MODIFICATION REQUEST:
Griffith Community Private Hospital and
Murrumbidgee Clinical Teaching and
Learning Centre
41 – 45 Animoo Avenue, Griffith
Project Approval (MP11_0053 MOD 1)

Secretary's Environmental Assessment Report
Section 75W of the *Environmental Planning and*
Assessment Act 1979

August 2014

DRAWING TITLE
GENERAL ARRANGEMENT PLAN

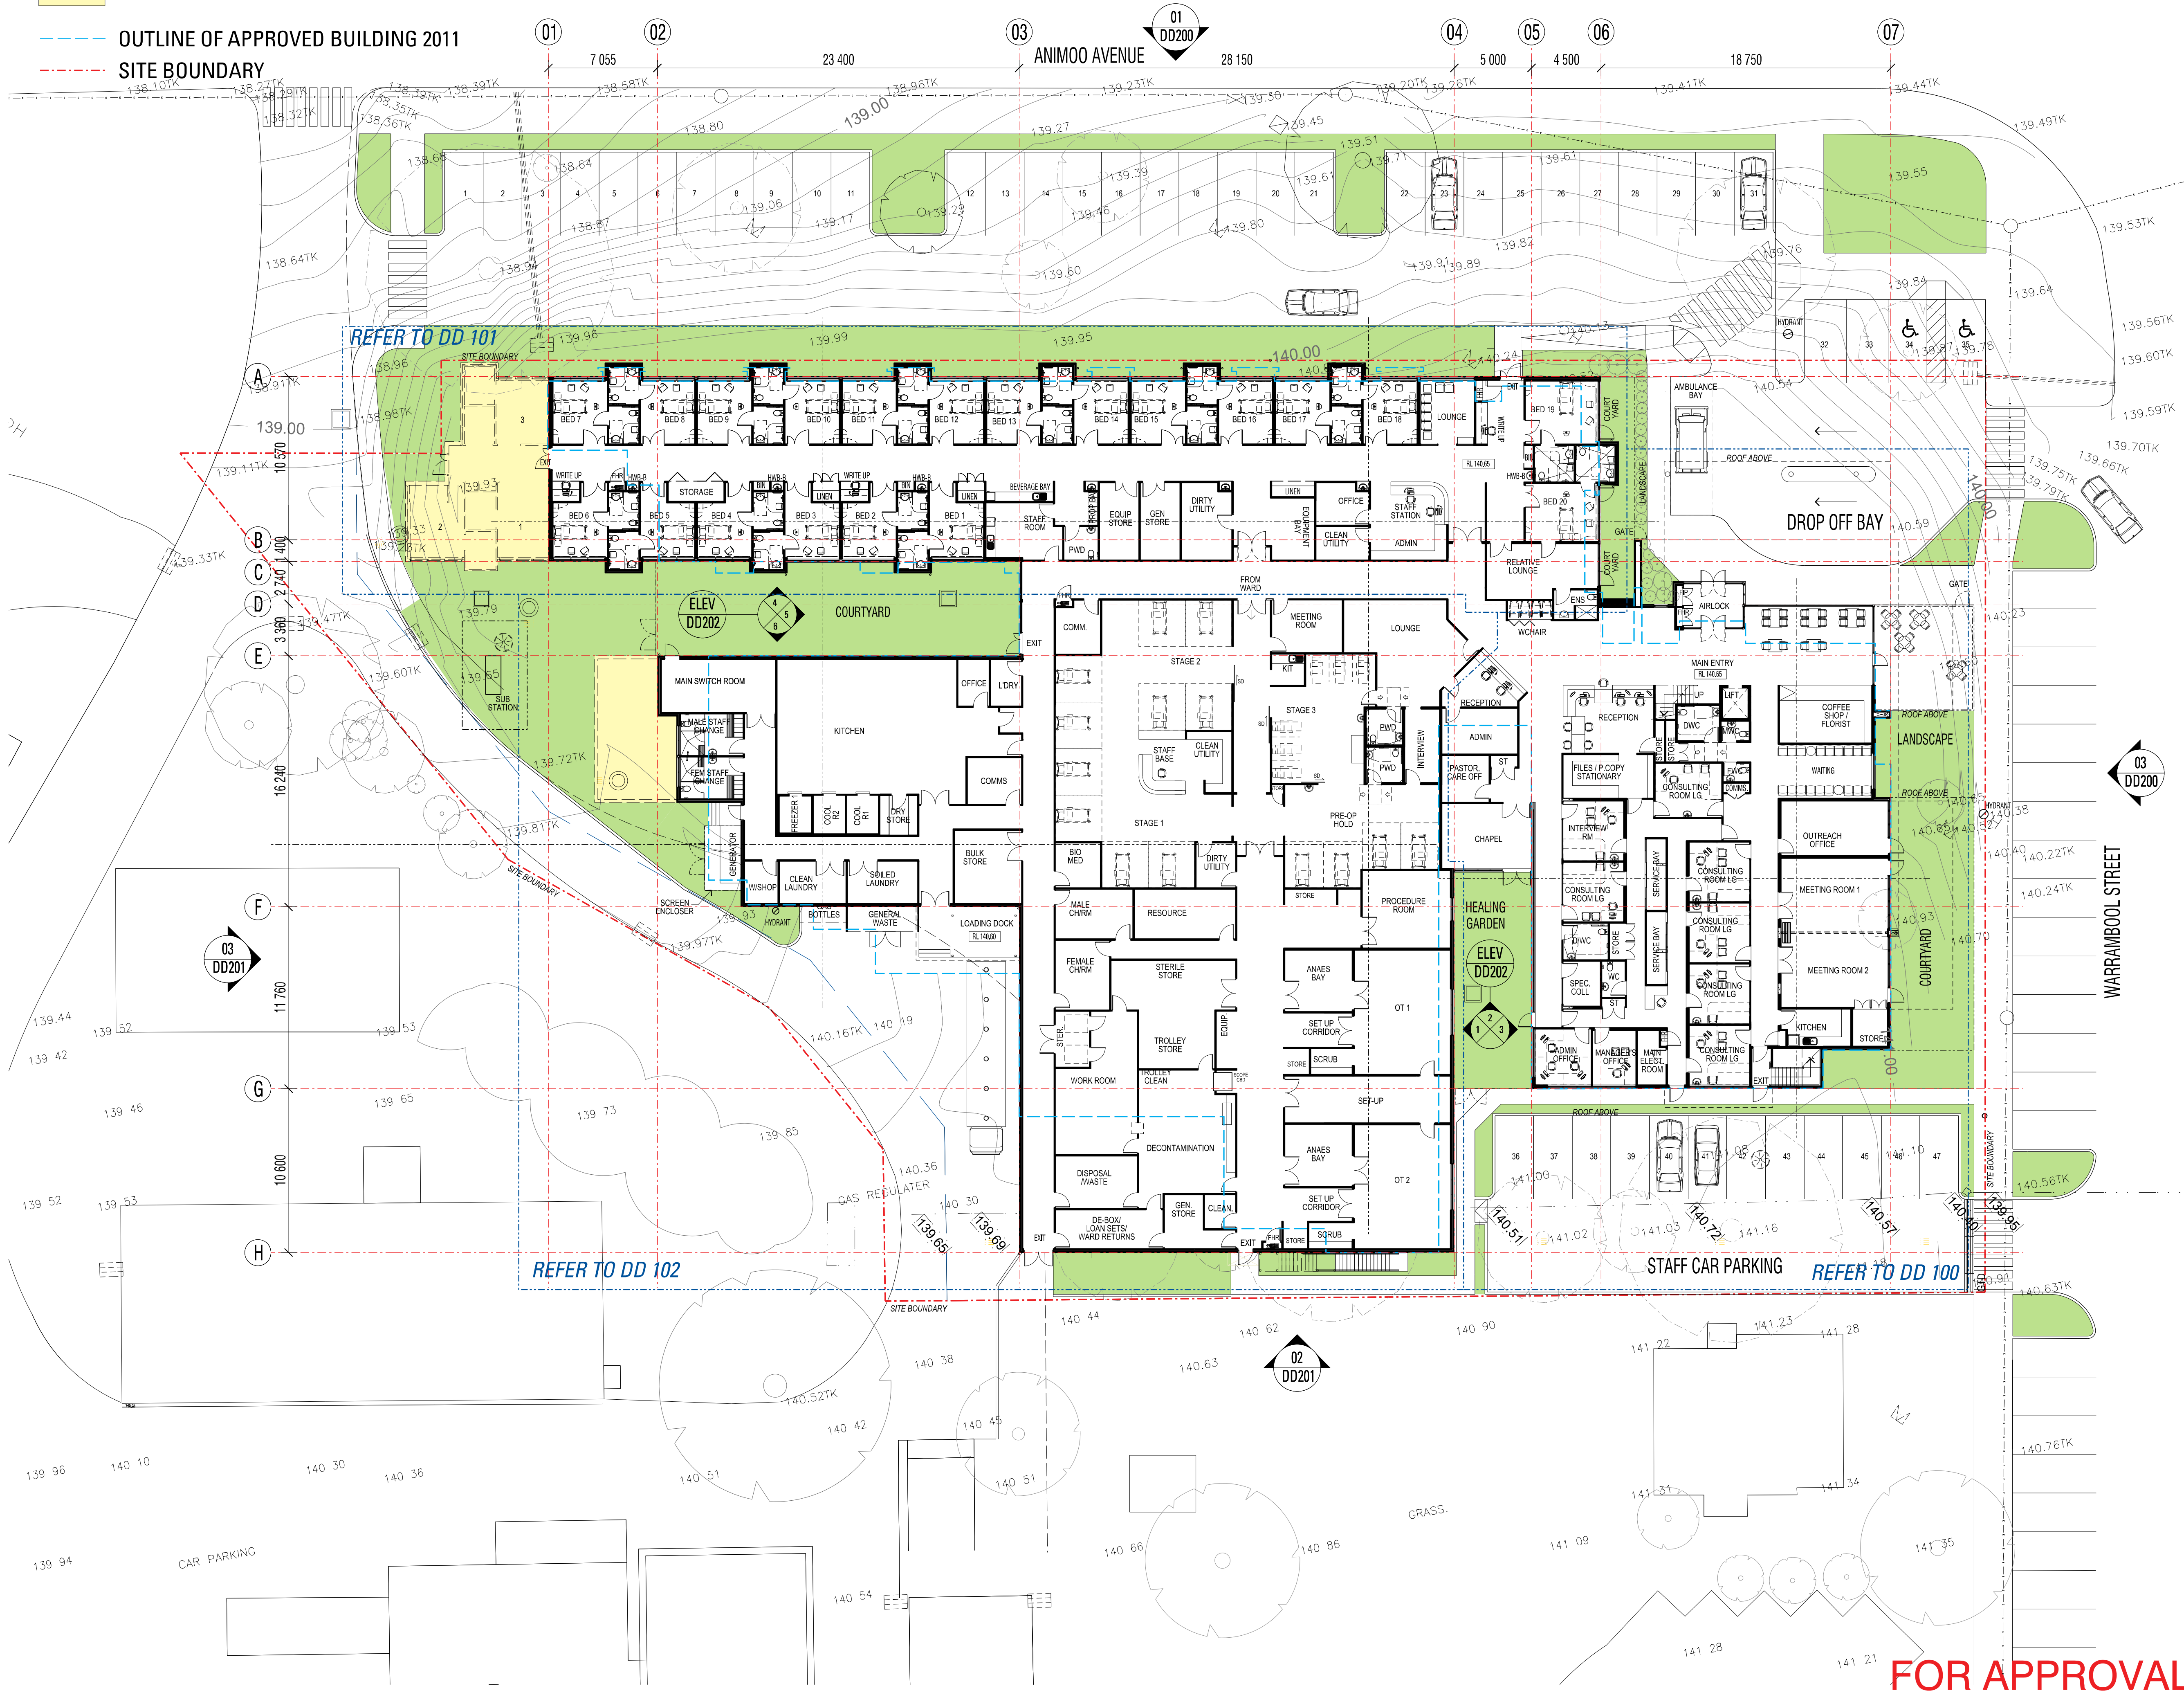
The proponent advises that the proposed modifications to the internal layout are required to improve the service provisions and functionality of the new hospital, particularly the provision of the new equipment sterilisation unit. The proposed amendments would increase the floor area from 2,895 sqm to 3,276 sqm (+381 sqm).

The largest floor area increases are proposed to facilitate a new equipment sterilisation unit (approx. +120 sqm) and Pastor's office (approx. +54 sqm), which were not previously considered in the original design of the hospital, and an extension to the meeting room and lounge room by infilling the internal courtyard area (approx. +90 sqm) (see **Figure 3**). The remainder of the proposed internal ground floor amendments are minor and result in inconsequential changes to the approved project.

Externally visible building amendments are located at the southern corner (new floor area to accommodate the new equipment sterilisation unit) and along the south-western elevation (amended layout to accommodate the rearrangement of the kitchen/laundry area and loading dock layout) (see **Figure 6 and 7**). The application also seeks to amend the location of the rooftop plant enclosure from the centre of the roof to the south-eastern edge of the building. The proposed relocation includes a minor increase to the size of the plant enclosure and relocation of the plant access staircase, modifying the appearance of the building, predominantly at its rear, south-eastern elevation (see **Figures 4 to 9**).

The application proposes to amend the location and arrangement of the loading dock and reposition the ambulance bay from the western side of the private hospital to adjacent to its front entrance (see **Figures 2 and 12**). The MLHD requested that a traffic management plan be provided to enable the access arrangement implications of the proposed modifications to be fully assessed.

Having regard to the original approved location of the loading dock, the department considers that the proposed relocated position of the loading dock improves the service vehicle access to and from the dock area. In addition to the existing conditions imposed as outlined above and further to the comments received from the MLHD, the department recommends a new condition be imposed requiring the preparation of a traffic management plan (in consultation with MLHD), prior to the issue of a construction certificate.

DRAWING TITLE  
**FIRST FLOOR PLAN**

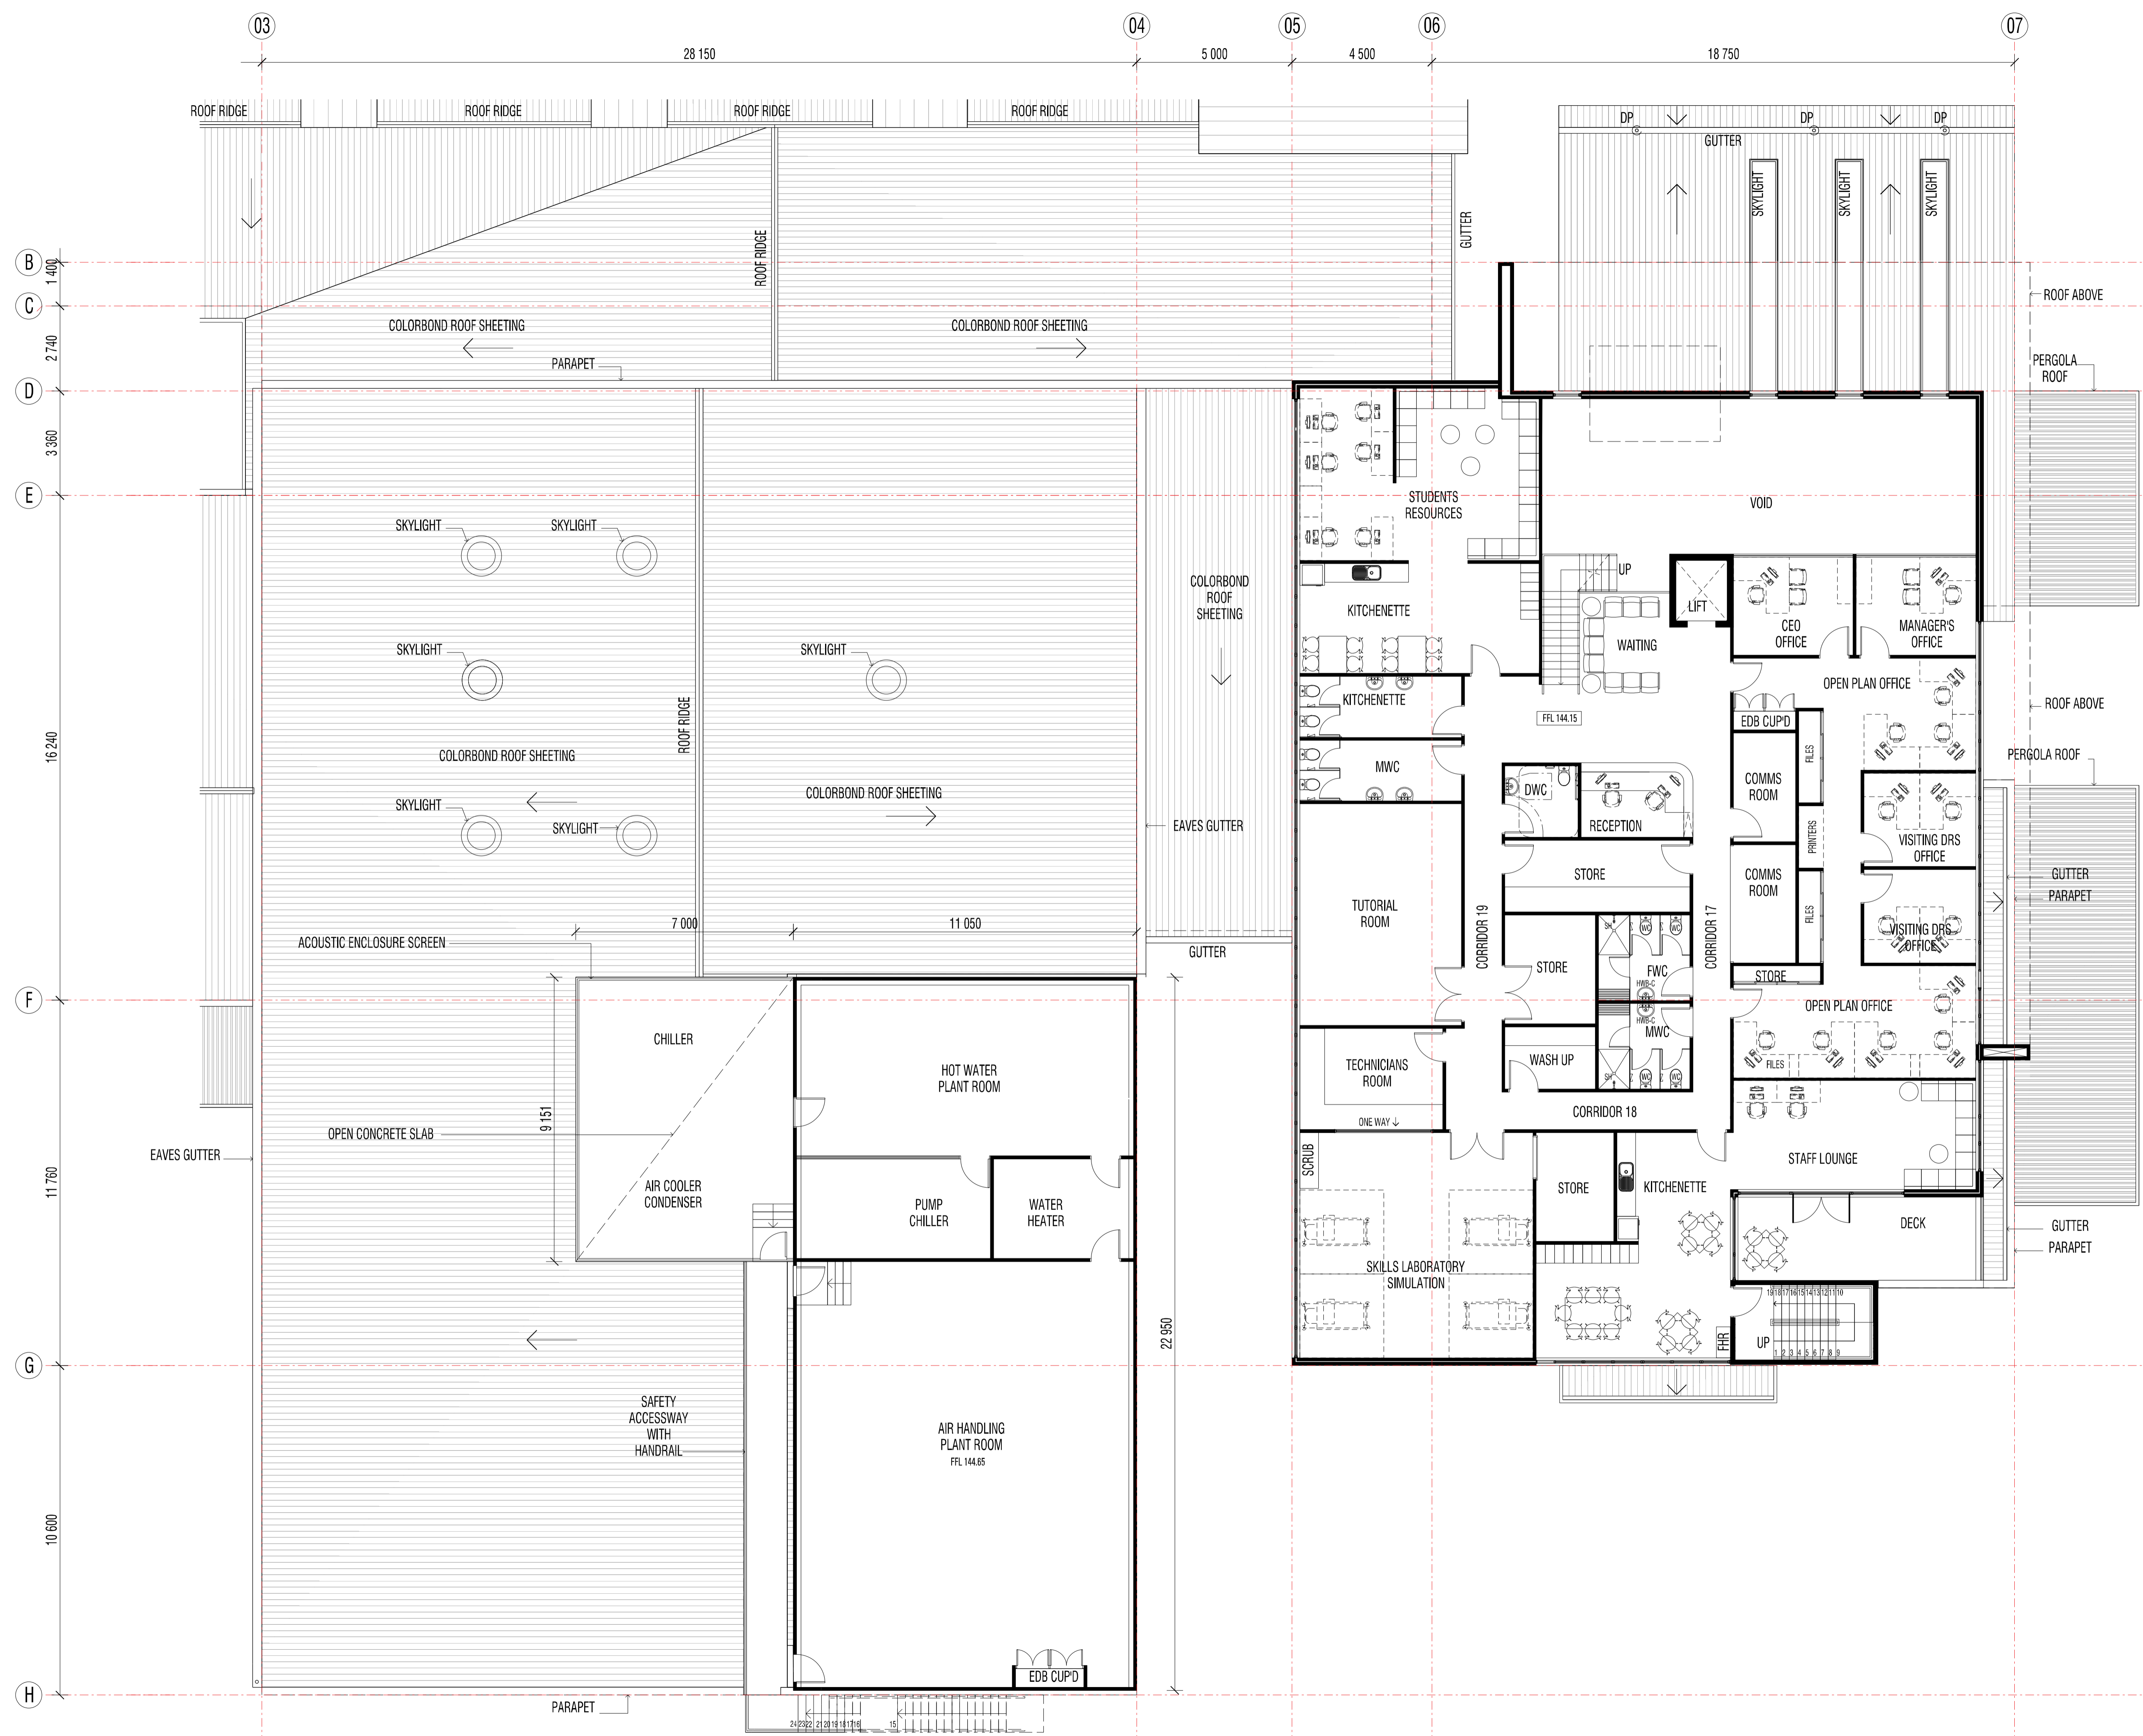
Modifications to the first floor of the teaching and learning centre are considered minor, with no additional teaching/learning capacity or students sought by this modification application (see **Figures 4 and 5**). Proposed amendments include minor increases in floor area to the staff lounge, kitchenette and student resources rooms.
